KITTTAS COUNTY COMMUNITY DEVELOPMENT SERVICES

RE: Boundary Line Adjustment (BL-25-00011) – Deemed Incomplete – Request for Additional Information

Kittitas County Community Development Services (CDS) received your Boundary Line Adjustment application (BL-25-00011 Sullivan) on August 12, 2025, for Parcels 508433, 478433, and 15747. Staff has reviewed your application and determined that more information is needed before this application can be processed any further. As such, Kittitas County declares your application **incomplete** as of August 21, 2025.

ADJUSTED BOUNDARIES

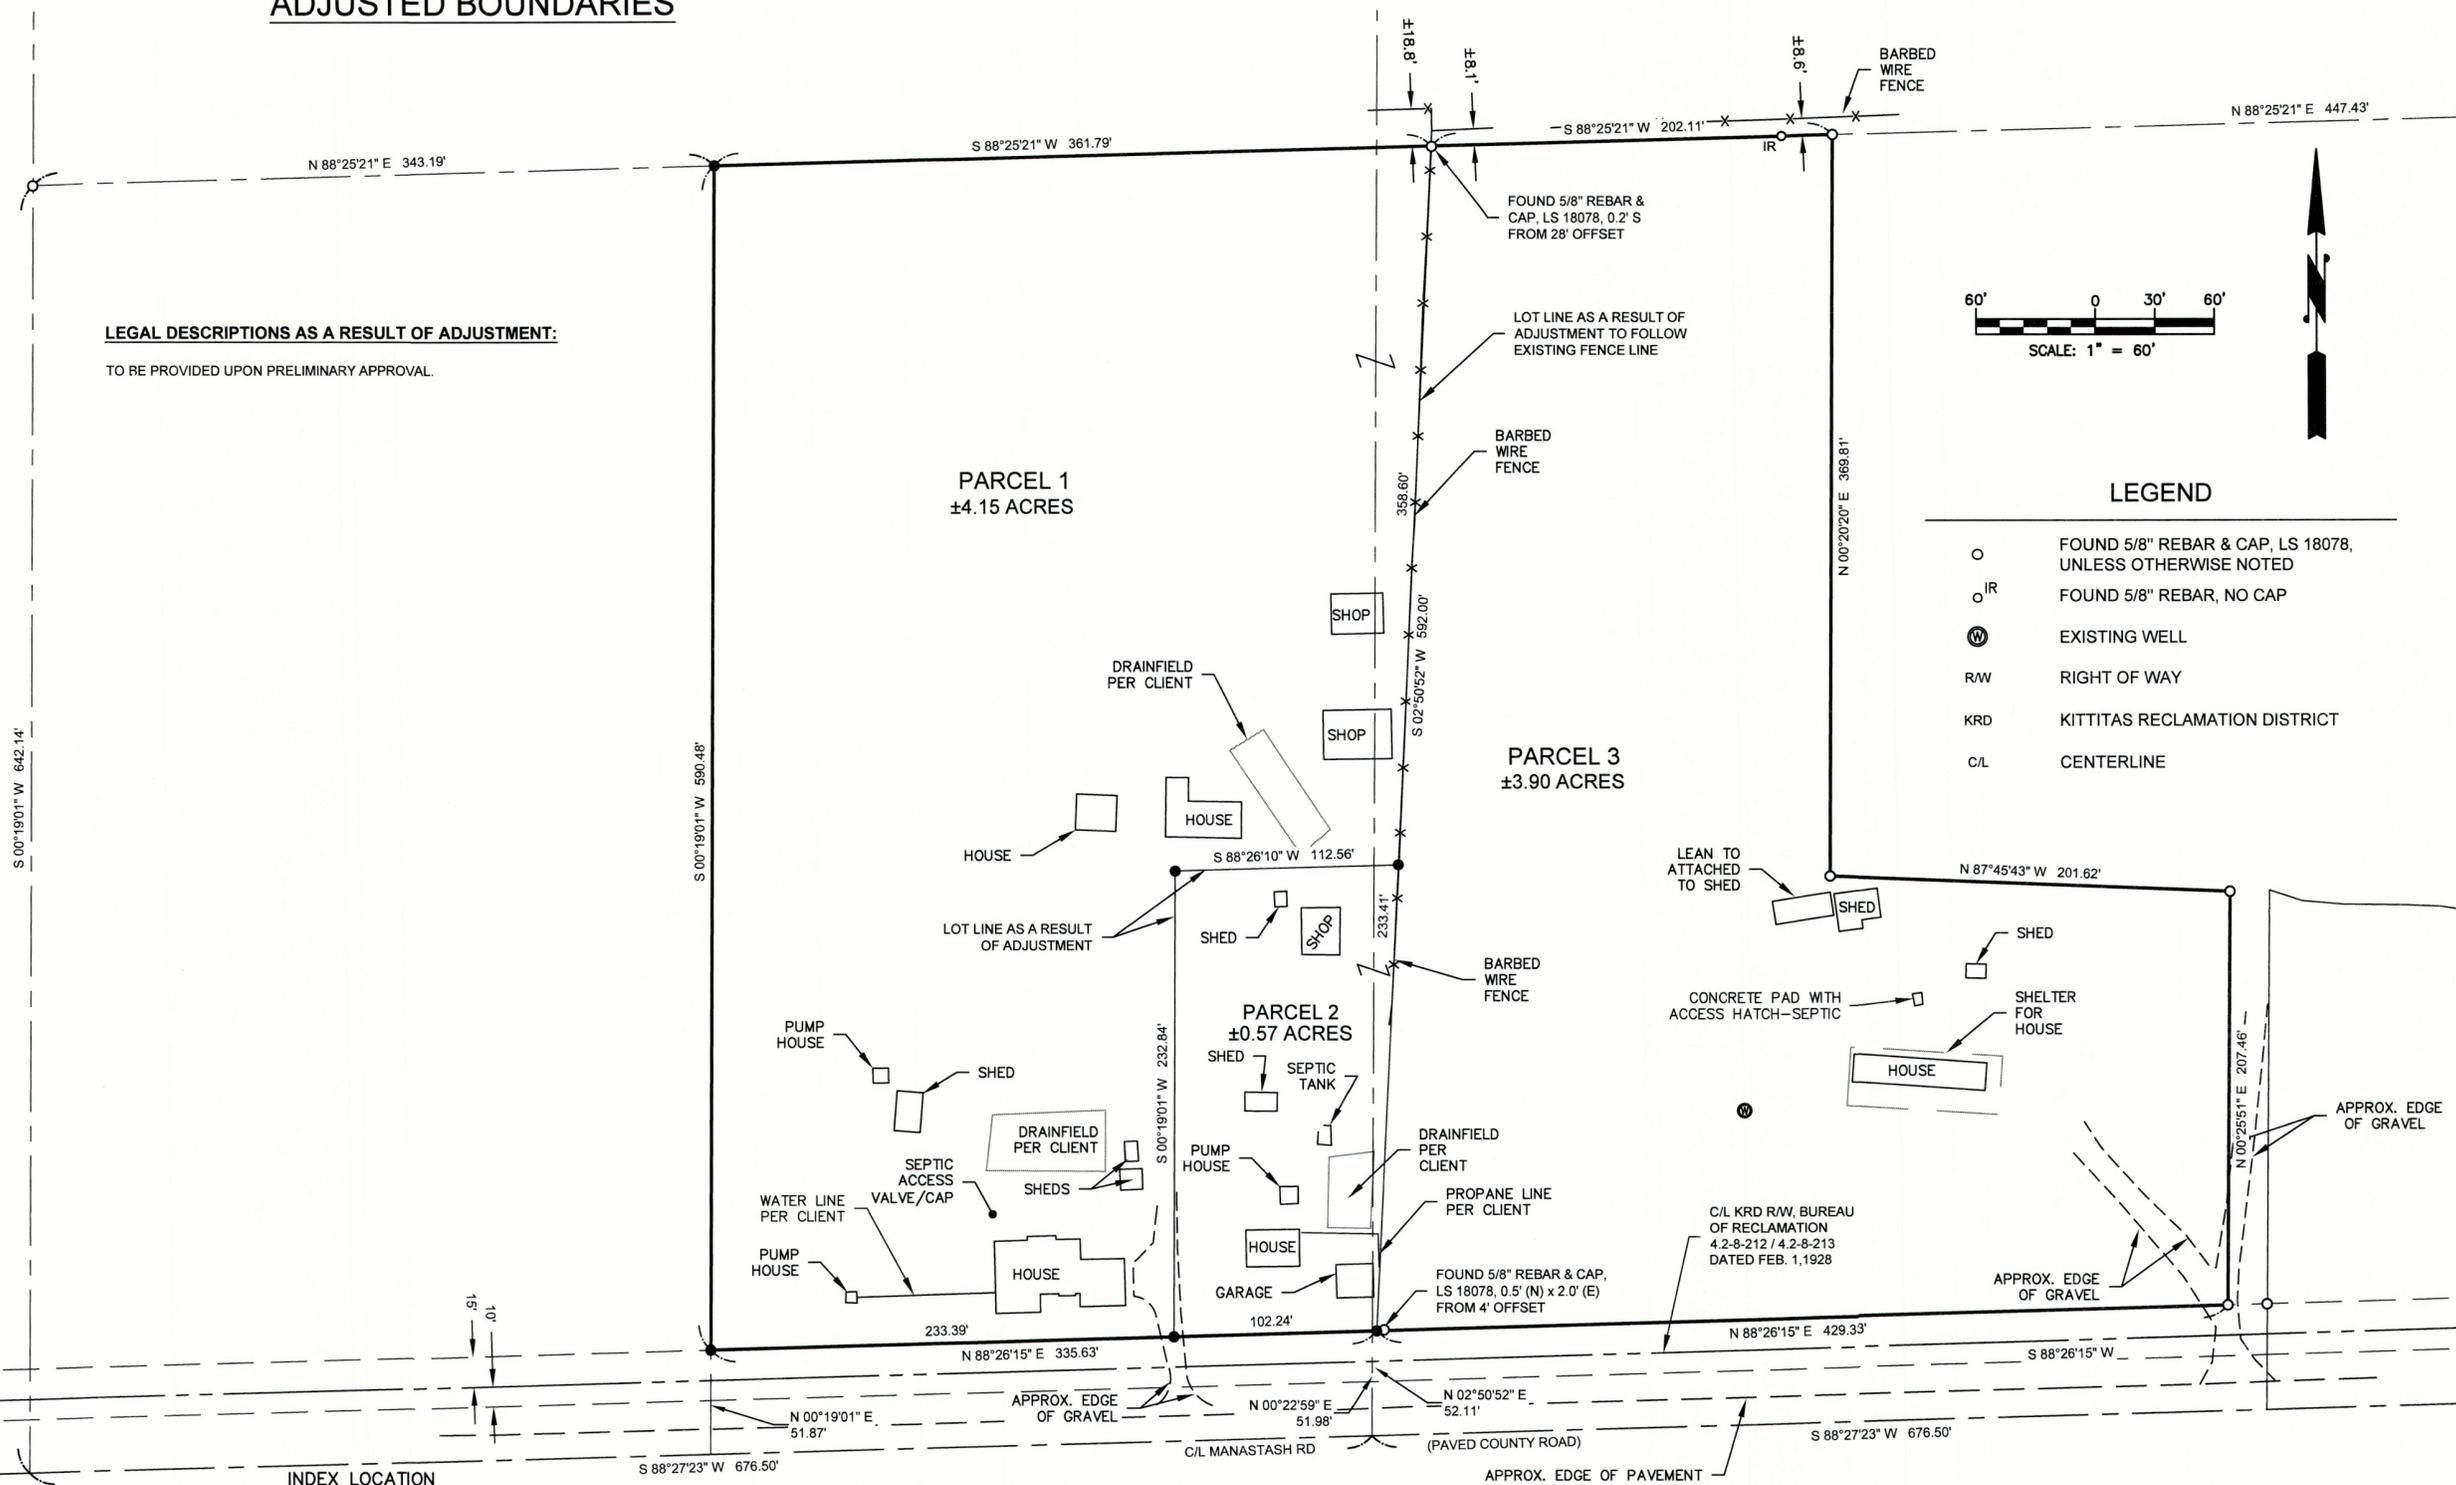
1. Please provide an updated site plan showing the measured distances of all existing structures, access points, well heads, and septic drainfields from the proposed lot lines. This is necessary to ensure lot line setbacks are being met.
2. Please provide a Certificate of Title, issued within the preceding one hundred twenty (120) days. The Certificate of Title attached to the application was issued November 25, 2024.
